KIRKLEES METROPOLITAN COUNCIL INVESTMENT & REGENERATION SERVICE

DELEGATED DECISION TO DETERMINE APPLICATIONS FOR CONSENT, AGREEMENT OR APPROVAL REQUIRED BY CONDITION

Reference No:	2025/44/93474/W
Site Address:	land off, Wood Lane, Colnebridge, Huddersfield, HD5 0PX
Description:	Discharge of details reserved by conditions 4 (boundary treatments), 5 (Remediation Strategy), 6 (Phase II Intrusive Site Investigation Report), 7 (Verification Report), 8 (noise), 13 (CEMP), 14 (invasive species), 15 (BEMP) on previous permission 2025/91053 for change of use and alterations to barn to form three dwellings including associated works
Recommending Officer:	Nicole Helliwell

DECISION – Discharge of Conditions – Split Decision

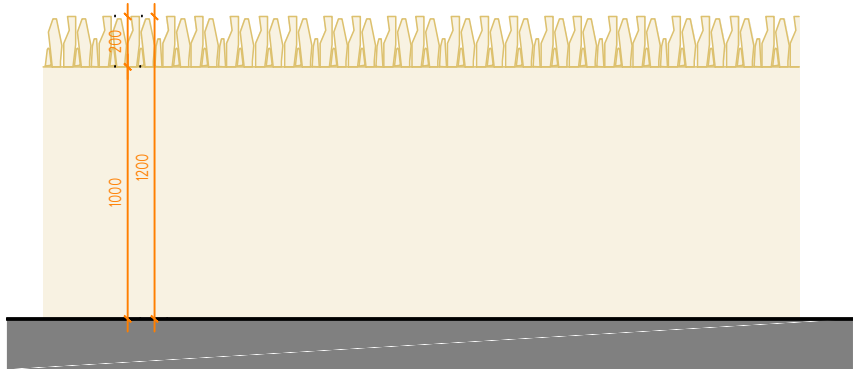
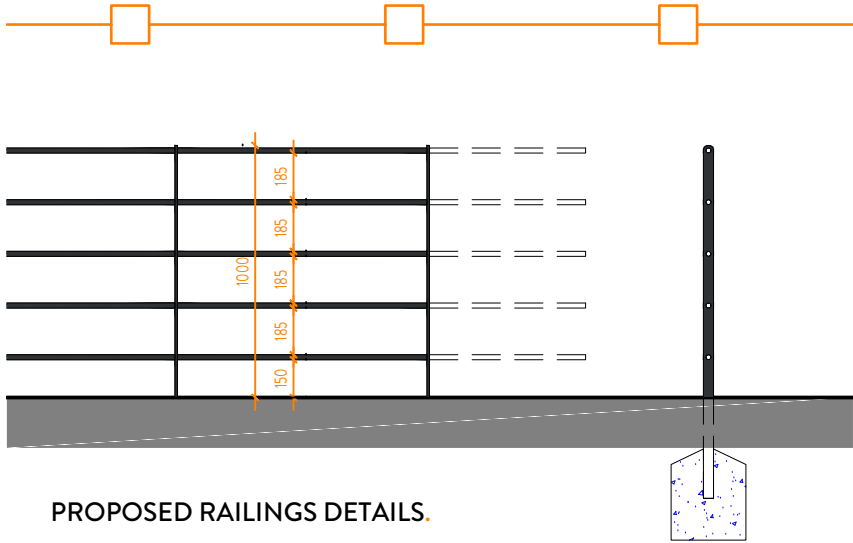
The applicant has submitted a Boundary Treatment Plan (reference no. (20)002 rev. A, dated 3rd March 2026) which details the location, height and materials of the proposed boundary treatments. The proposed boundary treatments would comprise a 1m high black painted metal railing along the northern boundary of the site to separate the residential properties from the greenway. It is also noted that a low level wall with fencing measuring 1.8m in height would be installed to enclose the private outdoor amenity spaces to the south of the plots. Furthermore, a 1.2m high dry stone wall is proposed along the perimeter of the site. The submitted plans confirm that this wall will be reduced to 0.9m within 2.4m of the kerb to ensure adequate visibility. The proposed boundary treatments would not cause any significant harm to visual amenity. Therefore, these details are deemed to be acceptable for the purposes of the condition and therefore condition 4 can be discharged. This is subject to the hereby approved boundary treatments being completed in accordance with the approved details and thereafter retained.

In conclusion, it is considered that the proposed boundary treatment details are acceptable for the purposes of condition 4. However, condition 4 can only be fully discharged when the boundary treatments are constructed and maintained in accordance with the details approved.
